**Consultation Response from KC,
Trees**

2024/93079 The Radcliffe, 444, Huddersfield Road, Mirfield, WF14 0EE

Change of use and alterations to care home unit 2 to form 10 self-contained apartments

Responding Ref: 10/92

Appendix 6: Arboricultural Implications Plan

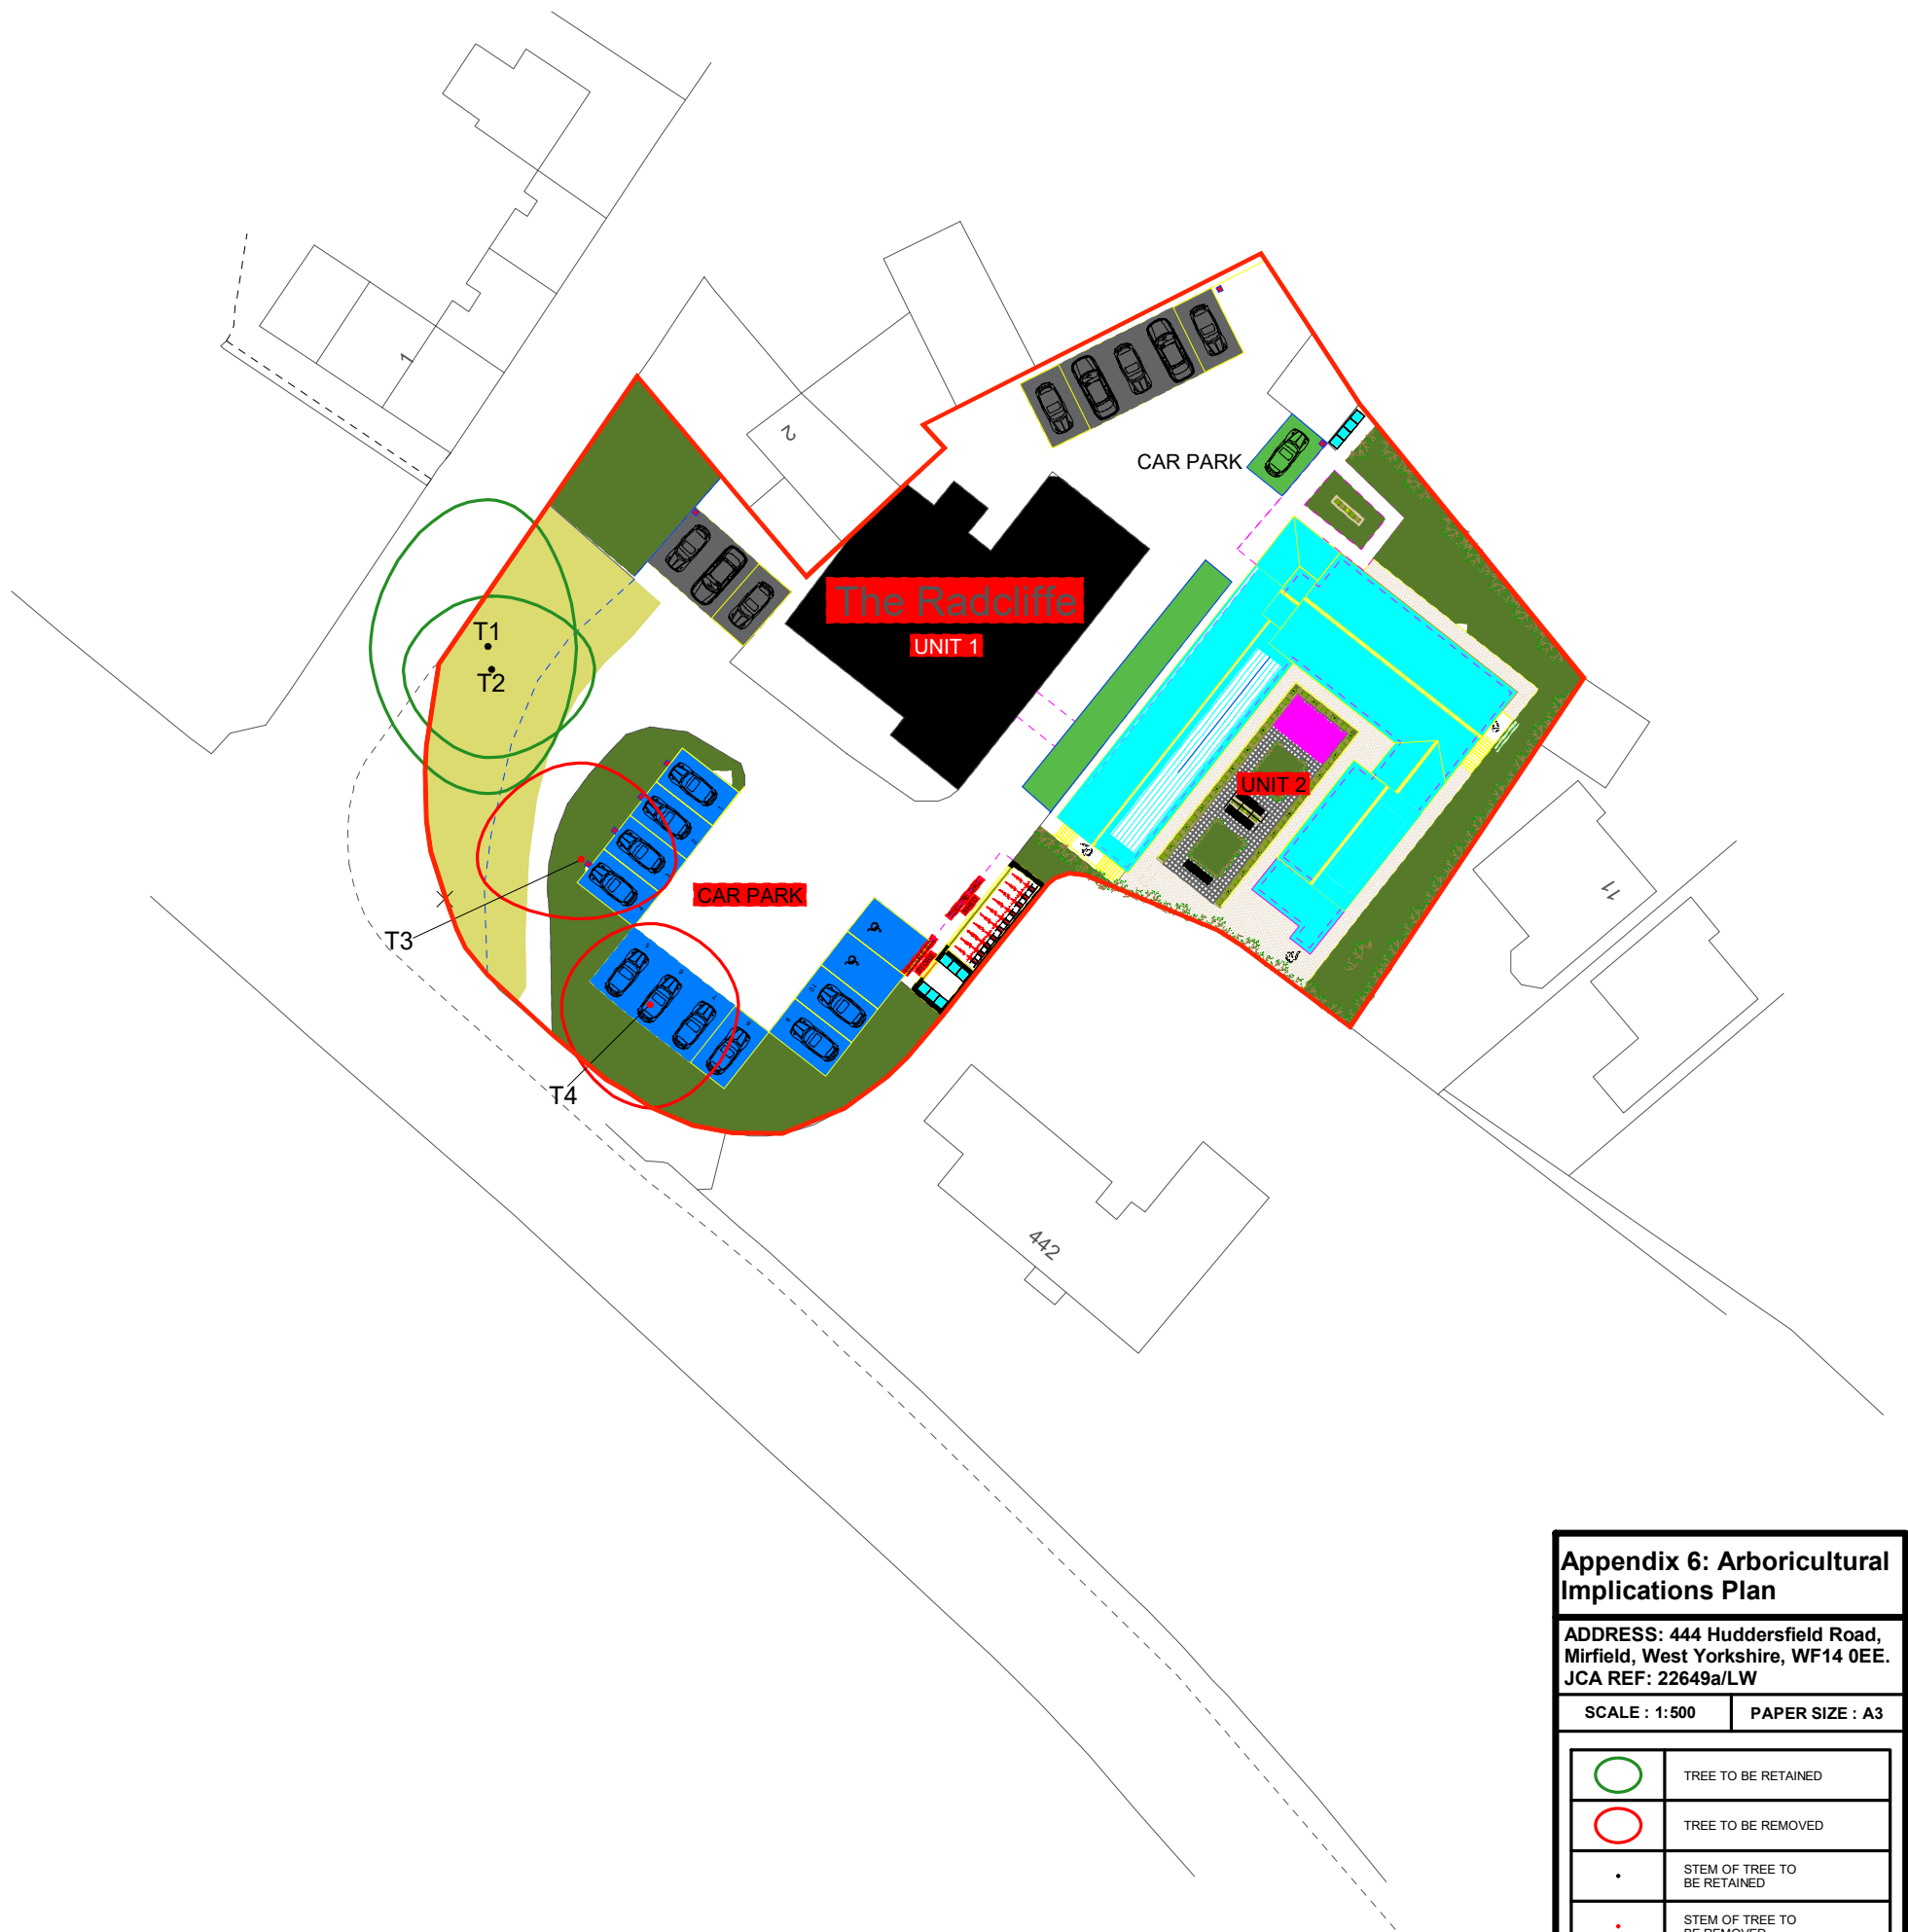
There are trees and hedges within the site, as well as off-site trees within the neighbouring property, which could potentially be impacted by the development of these proposals. **All trees included within the arboricultural survey are subject to TPO ref. 10/92.**

All trees included within the survey are legally protected by a TPO and must be retained to preserve the amenity value they provide to the local area. There is an objection from an arboricultural perspective. The proposal conflicts with adopted Kirklees local plan policy 33 and 24 (i).
